PROJECT NO. 1002320	APPLICATION NO. 02DRB -01661
PROJECT NAME Muriel T MATTHEWS	
EPC APPLICATION NO.	
APPLICANT / AGENT Rebecca S. Herly	PHONE NO. 764-5400
ZONE ATLAS PAGE J-13	238-5151
<b>ONE STOP COMMENT FORM LOG</b>

PLAT OF  
LOTS 1 AND 2  
LANDS OF MURIEL T. MATTHEWS TRUST  
CITY OF ALBUQUERQUE, BERNALILLO COUNTY  
NEW MEXICO  
AUGUST 2002

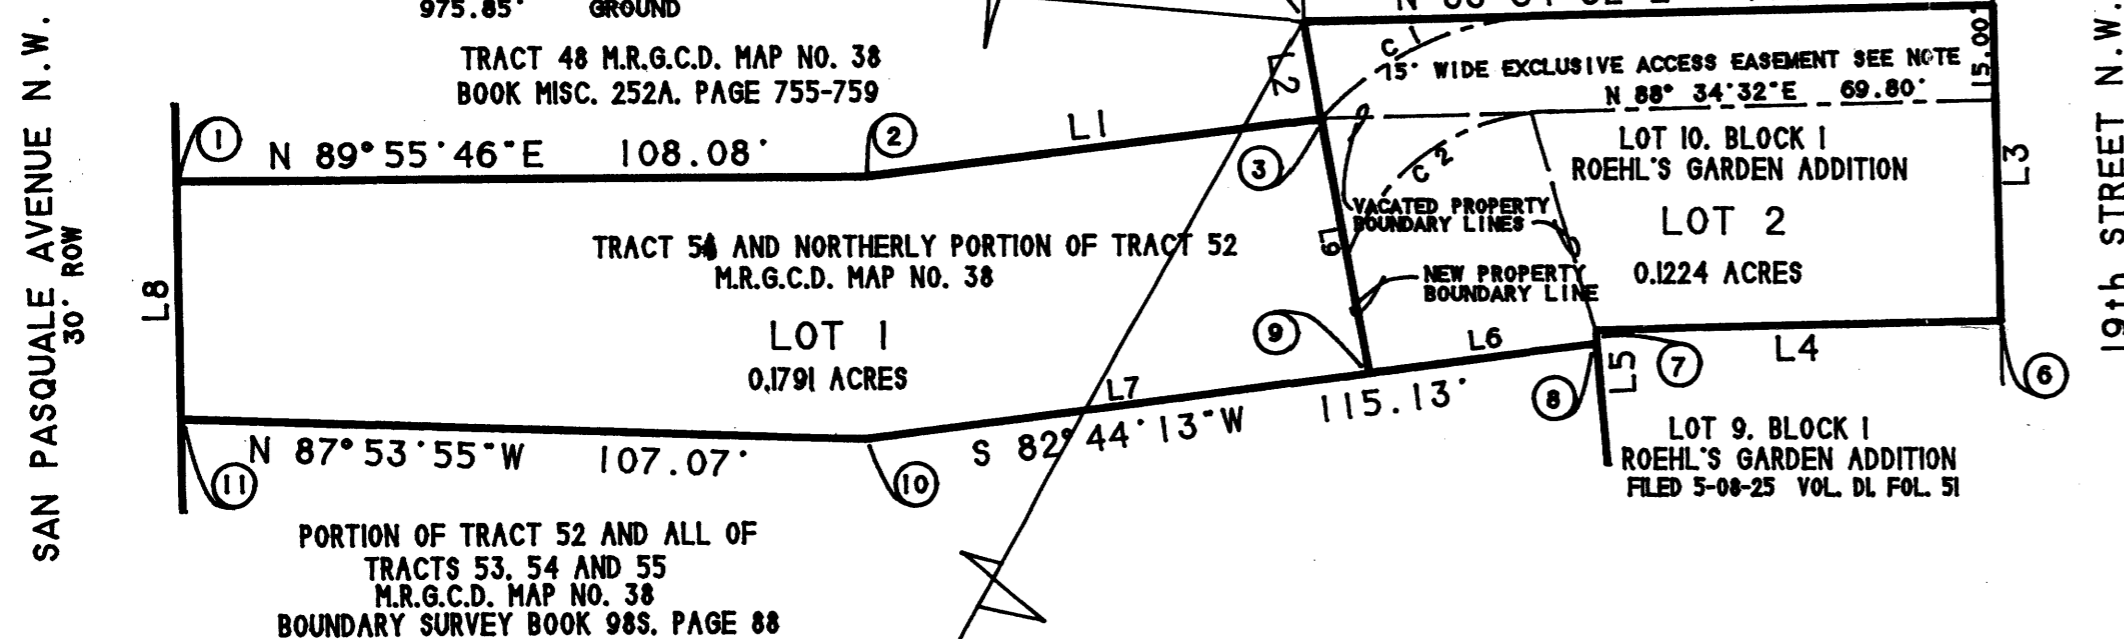
<b>TRANSPORTATION DEV (505) 924-3990</b>		
PLANS DISAPPROVED	DATE 10-29-02	DATE
PLANS APPROVED	DATE 11-05-02	DATE
1-A side sketch is needed showing R/W and SDWK, curb & gutter. 2- R/W dedication is likely. Bld too close to rd on 19th Adequate space on San Assuel (one-way street) 11-08-02
